RE: EXHIBITION OF MODIFICATION TO RUSHES CREEK POULTRY PRODUCTION FARM (SSD-7704-MOD-3)

I refer to your email correspondence dated 18 January 2022, seeking Council's comment with regards to Modification 3 to SSD-7704, Rushes Creek Poultry Production Farm.

Council's staff have reviewed the Modification Report, prepared by ProTen, dated January 2022 and provide the following advice;

Figure 1-1: Development Layout (Source: EME Advisory)

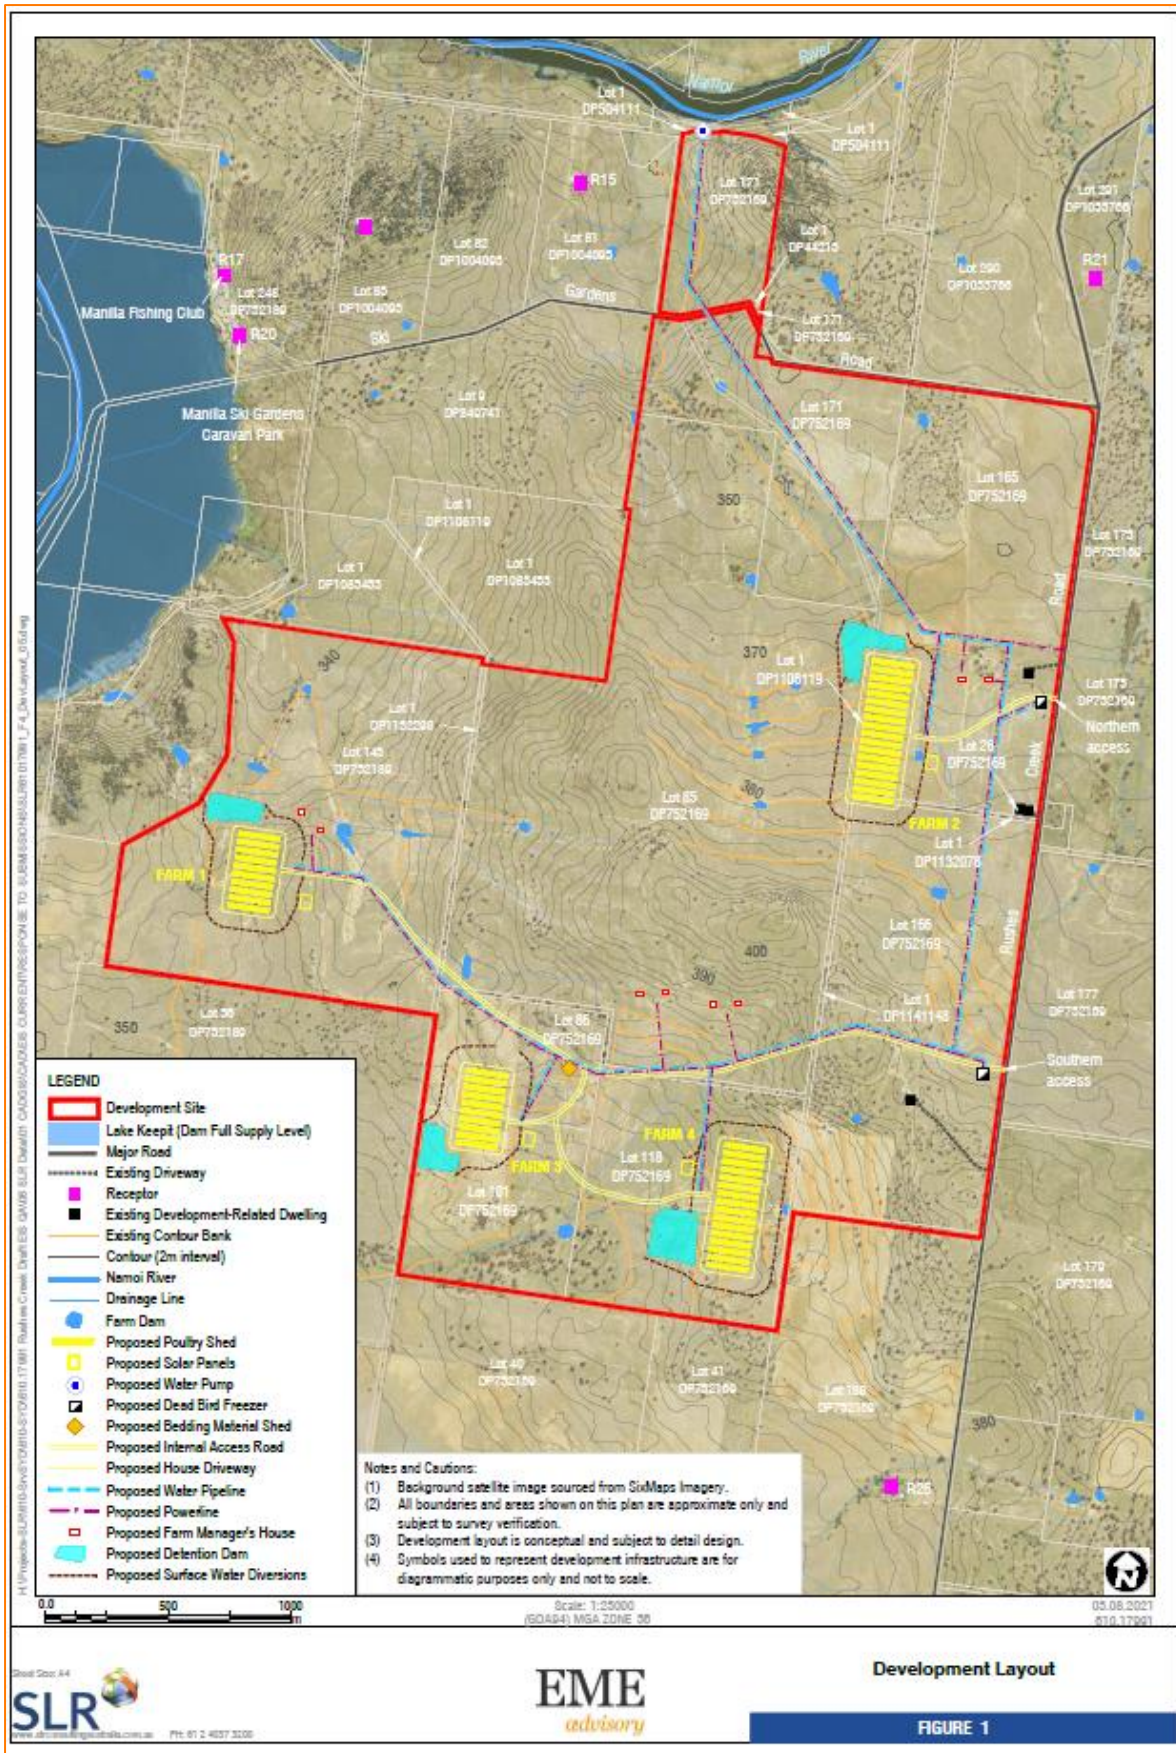
- 1) The modification involves the use of 440 kVA diesel generators to operate Farm 2 and a 45 kVA diesel generator to operate the water supply pump for up to 10 months while an alternative renewable option is finalised, approved and commissioned. It is understood that ProTen is currently pursuing an option to take the development off-grid with solar and battery technology and that this will be subject to a separate modification application.

- 2) The proposed bunded diesel storage tank should be located outside any portion of the site identified as flood prone land.
